Road Safety Audit

Wendlebury Road, Bicester

Road Safety Audit
Stage 1

23 May 2019

JOB TITLE		CLIENT	
CATALYST BICESTER		ALBION LAND	
DRAWING TITLE			
WENDLEBURY ROAD FOOT/CYCLEPATH ENHANCEMENT WITH HEALTH AND RACQUETS CLUB			
SCALE	DRAWN BY	DATE	DRAWING No
1: 500@A1	RJM	03/05/19	19539-12-01
			REVISION
			B

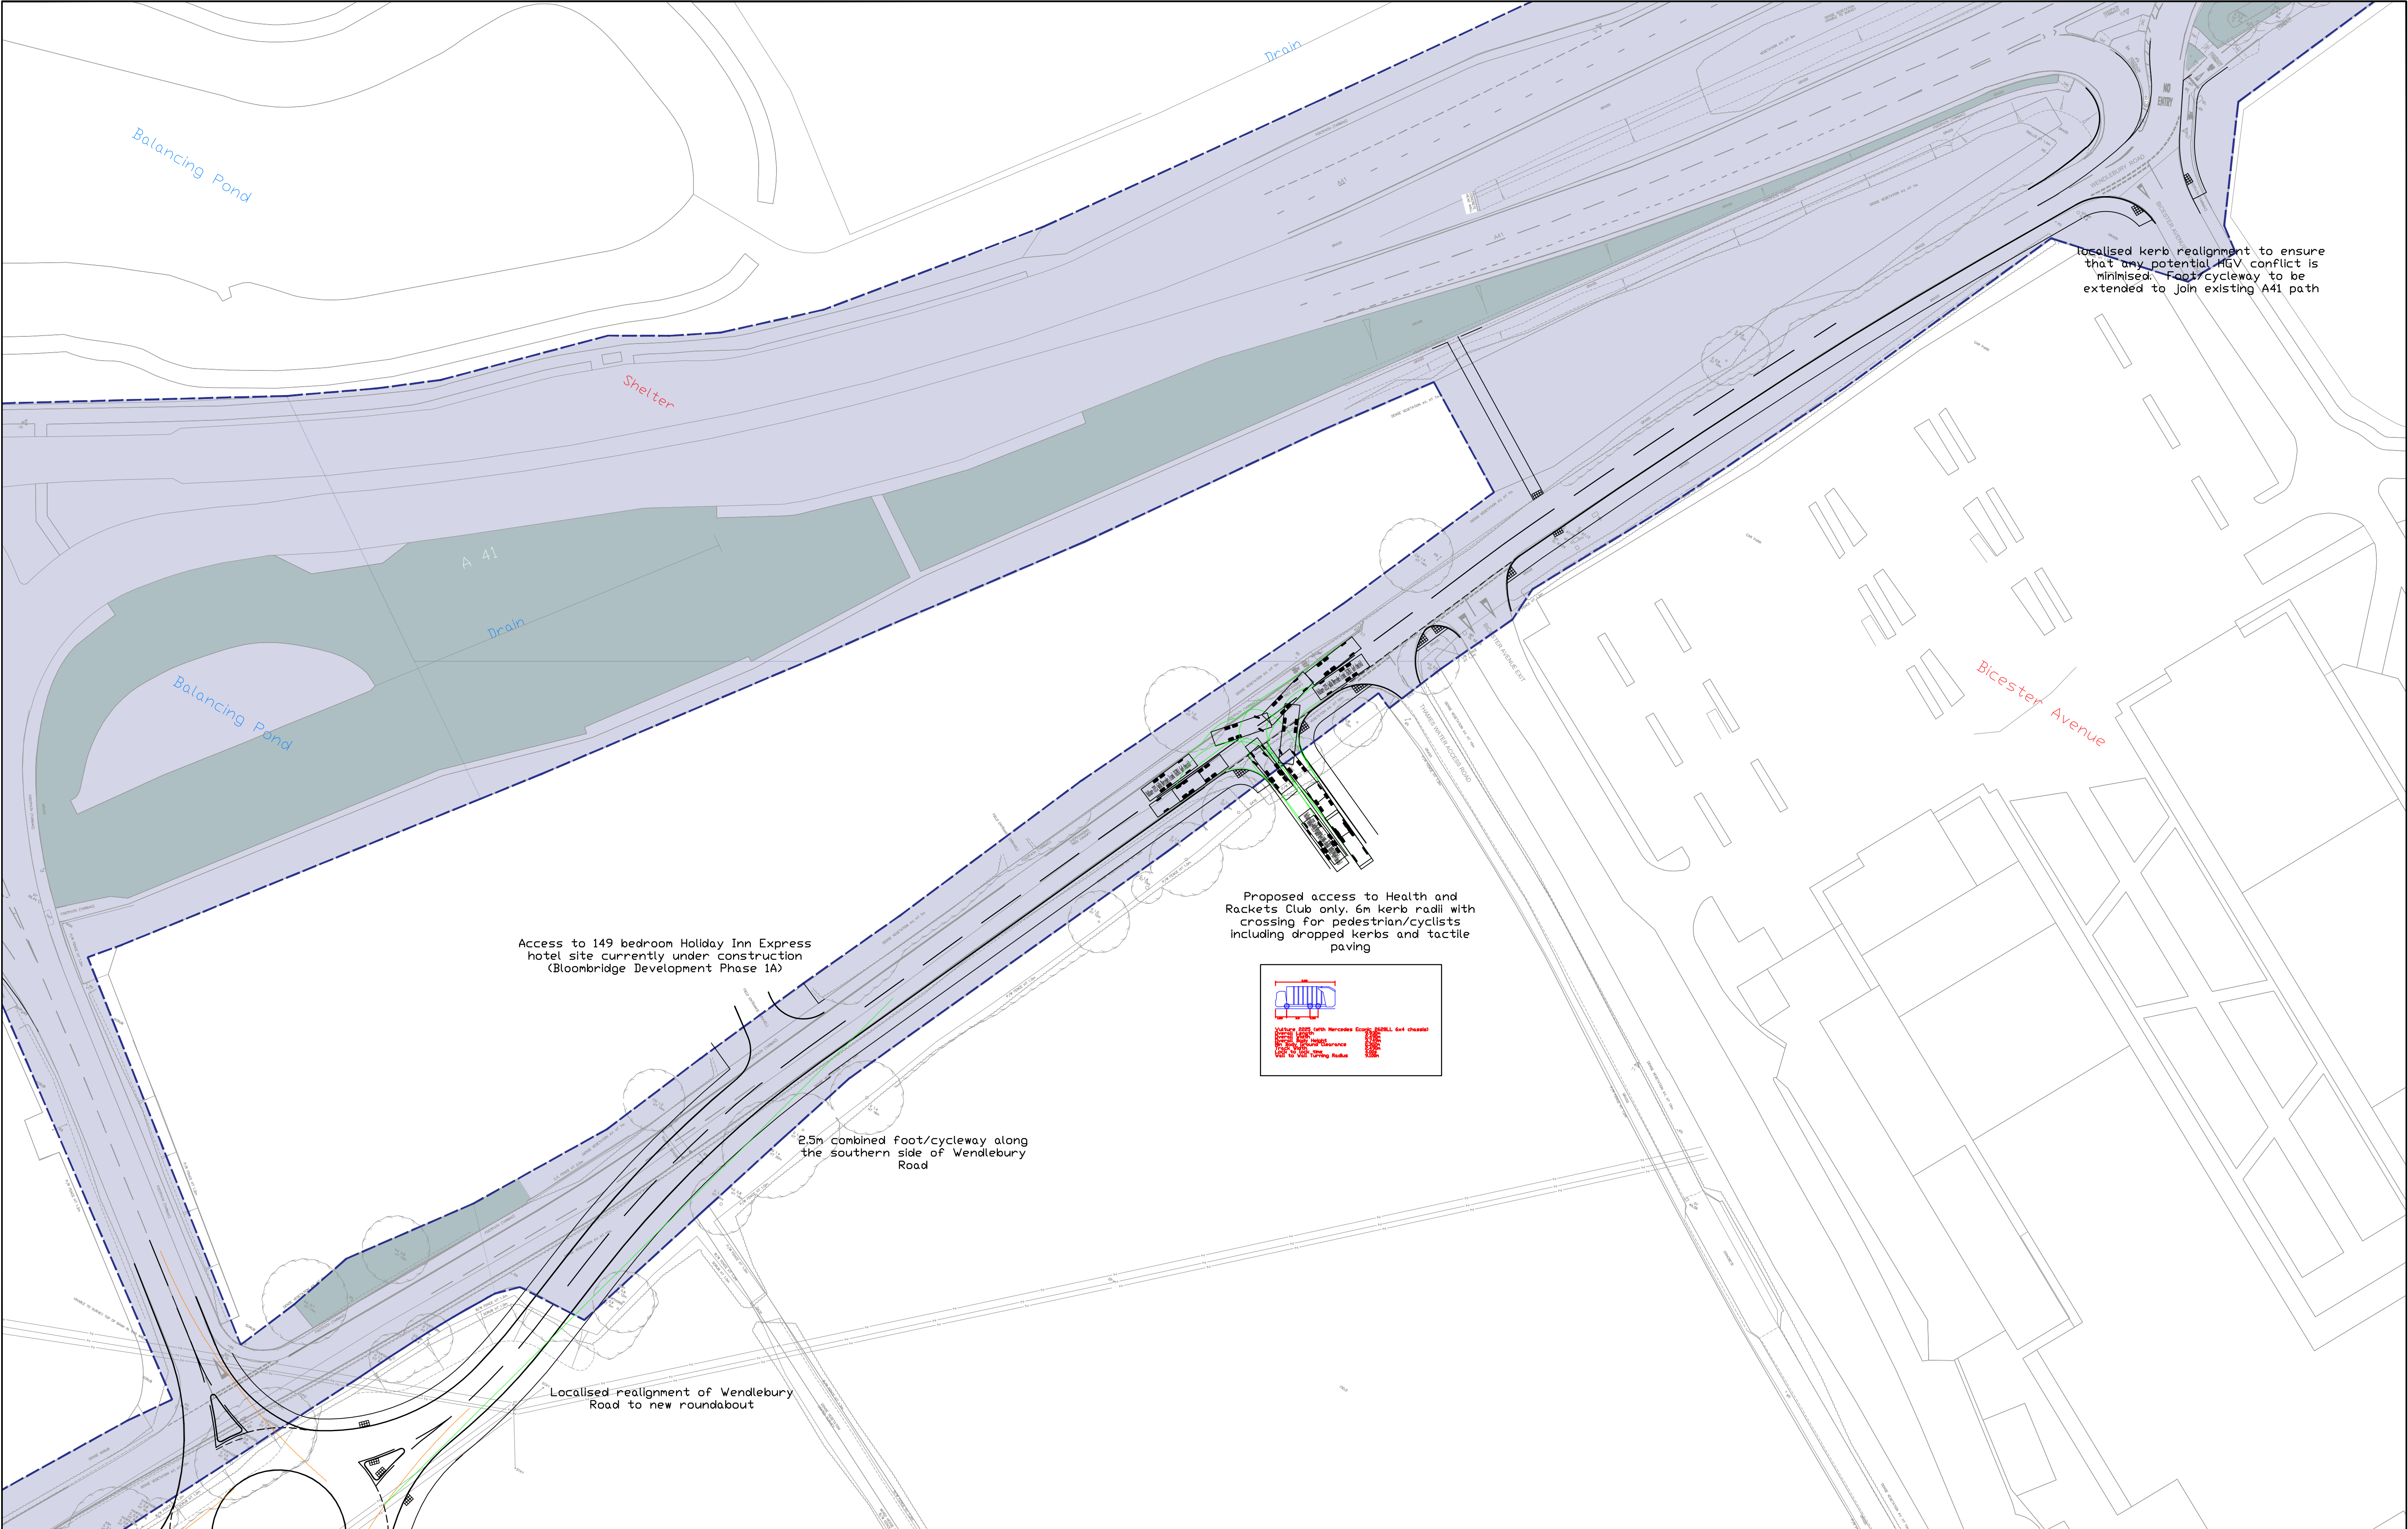
Location: Southern side of Wendlebury Road.

Summary: Drop at back of footway may present a hazard to pedestrians.

A new 2.5m footway / cycleway is proposed along the southern side of Wendlebury Road. There is an overgrown ditch running the length of Wendlebury Road throughout the scheme, with a noticeable level difference from the carriageway level to the bottom of the ditch. Provision of a footway at this location will result in drop at the back of the footway, which may present a hazard to pedestrians or cyclists should they leave the paved surface. This may result in falls resulting in personal injury.

It is recommended that a fence or guardrail is provided at the back of the footway wherever a drop to surrounding surface levels is present. Alternatively, ground at the back of the footway should be graded to avoid a steep drop.

JOB TITLE CATALYST BICESTER		CLIENT ALBION LAND	
DRAWING TITLE WENDLEBURY ROAD SITE ACCESS ROUNDABOUT			
SCALE 1: 500@A1	DRAWN BY RJM	DATE 03/05/19	DRAWING No 19539-12-02
REVISION B

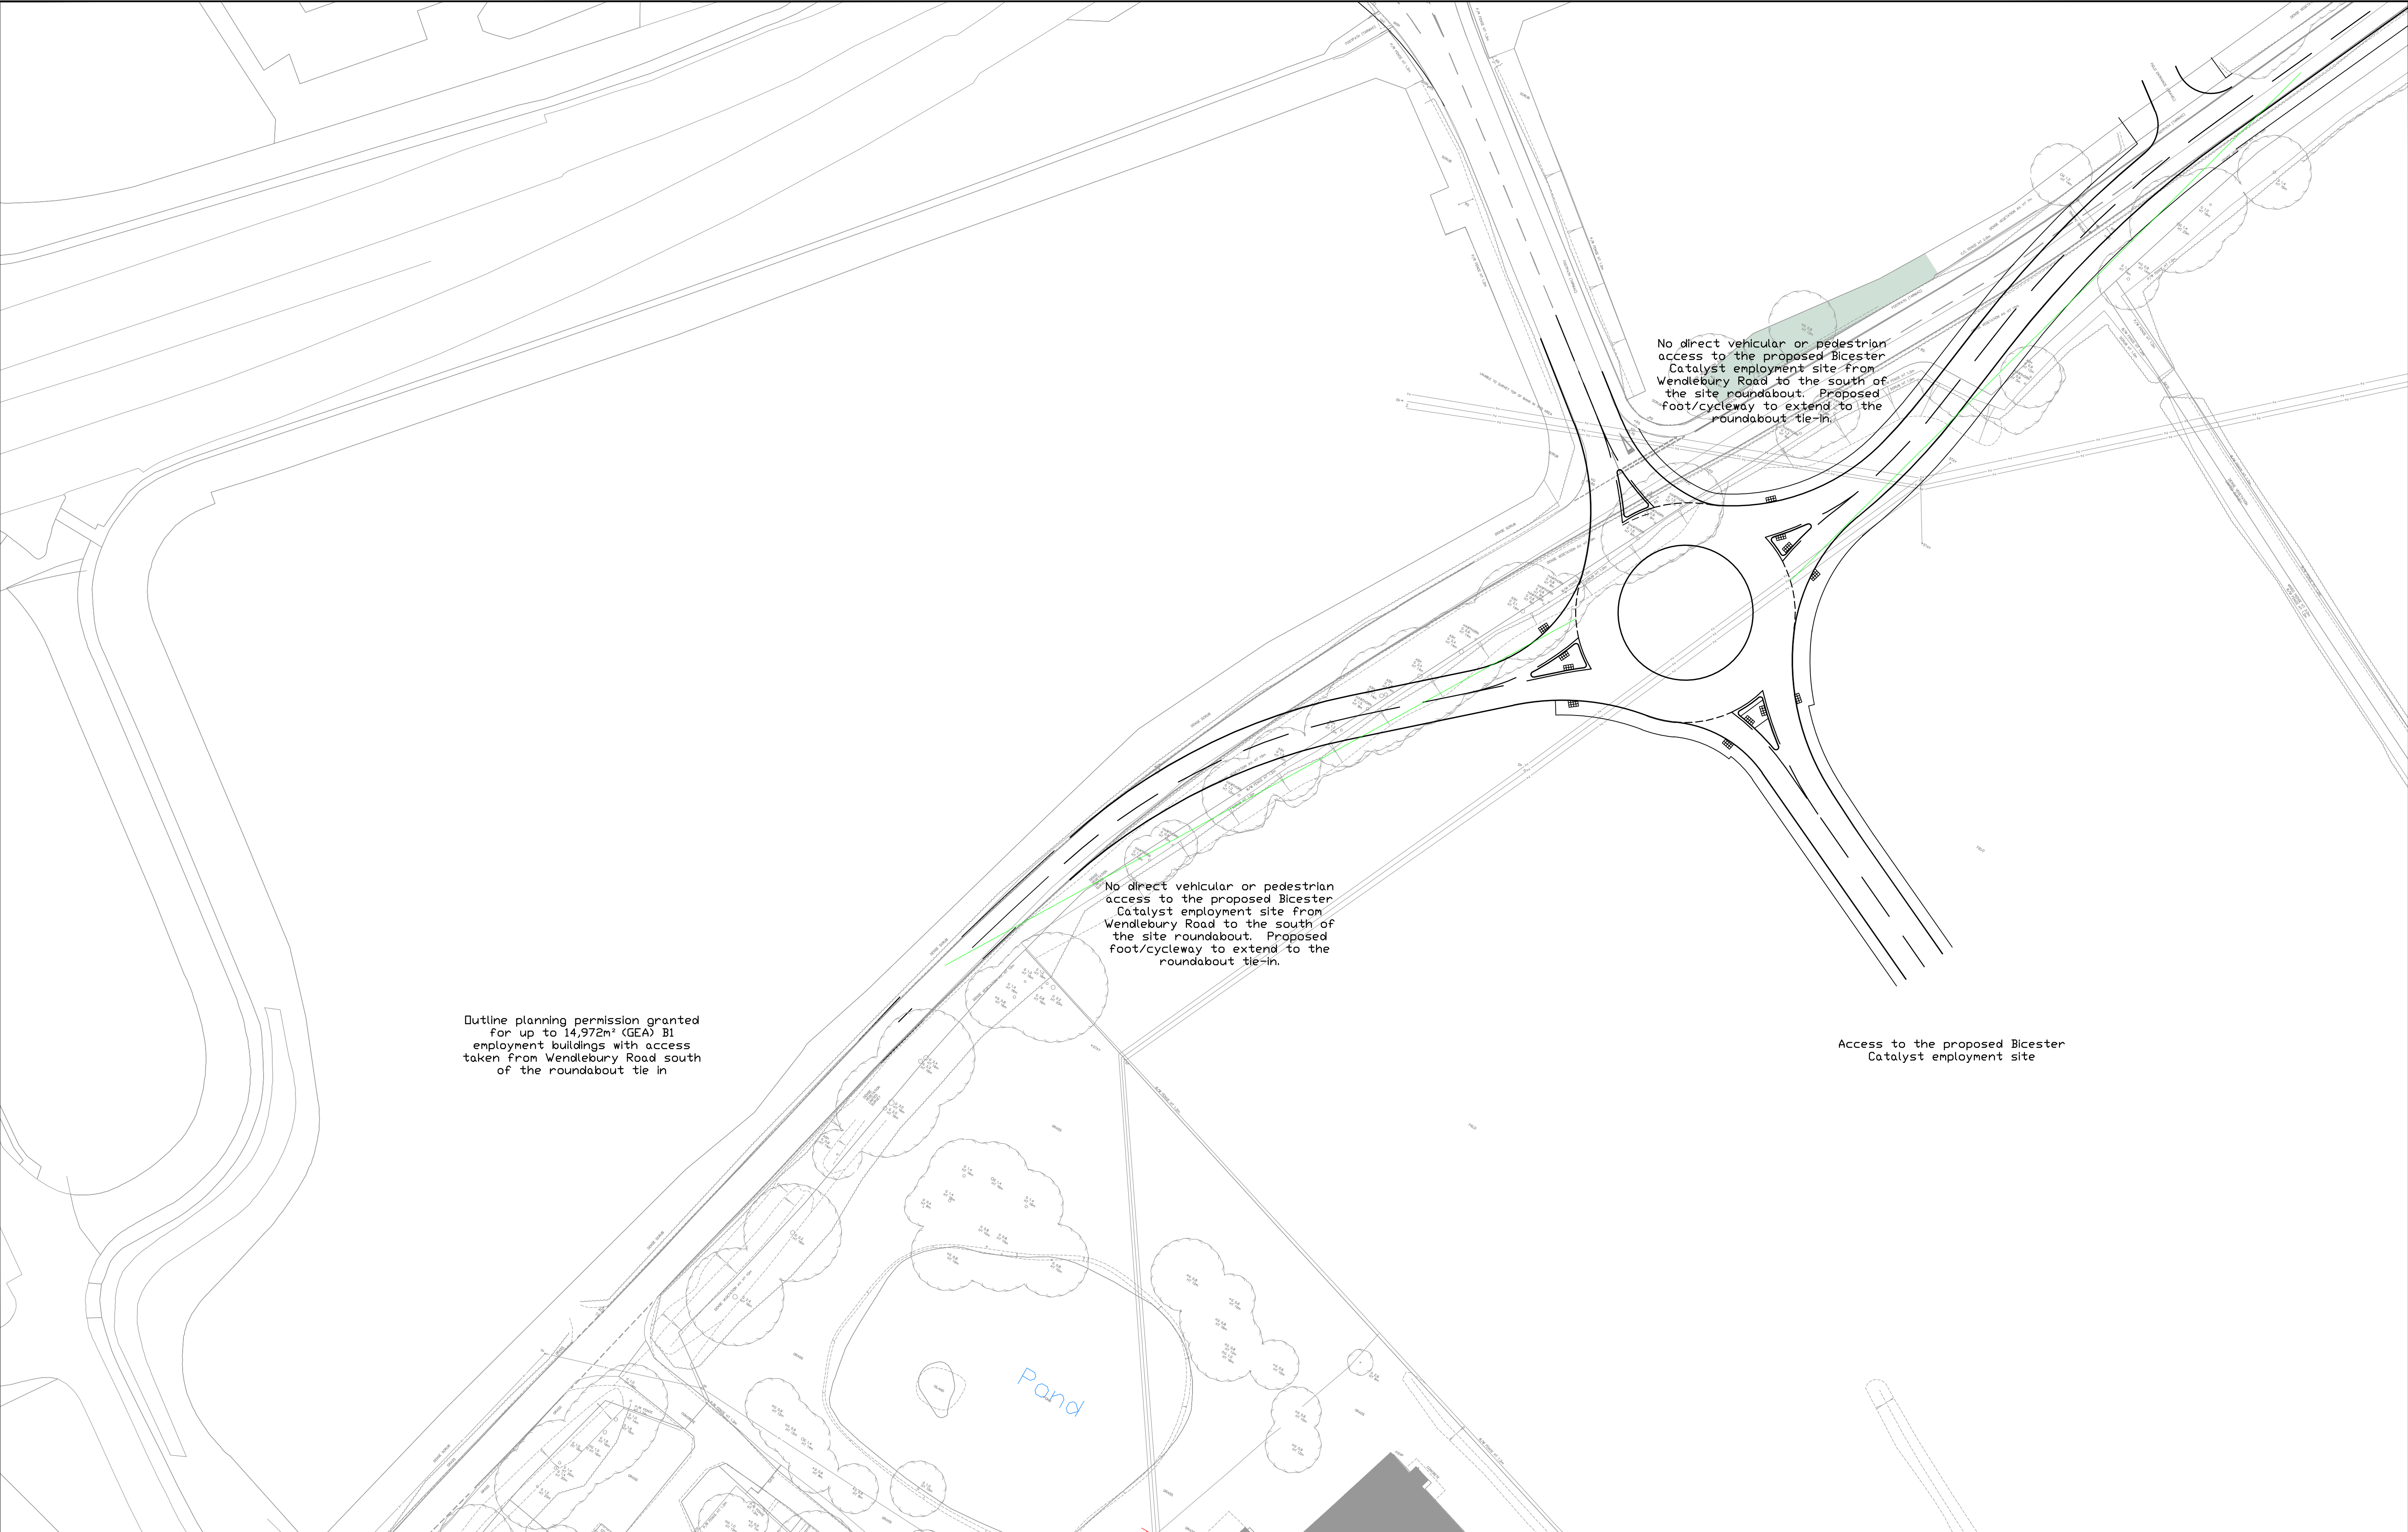
Location: Wendlebury Road – western extent of scheme.

Summary: Unclear end of footway / cycleway.

A new 2.5m footway / cycleway is proposed along the southern side of Wendlebury Road. It is proposed that this will continue to the west of the proposed roundabout, but there are no existing footway / cycleway provisions on this side of the junction. It is unclear if there will be a demand in this direction and therefore the continuation of the footway / cycleway may encourage users continuing to the west to enter the carriageway increasing their vulnerability to being struck.

It is recommended that appropriate tie-ins with surrounding facilities are provided. If no pedestrian / cyclist demand is anticipated in this direction, the footway / cycleway to the west of the roundabout should be omitted from the scheme.
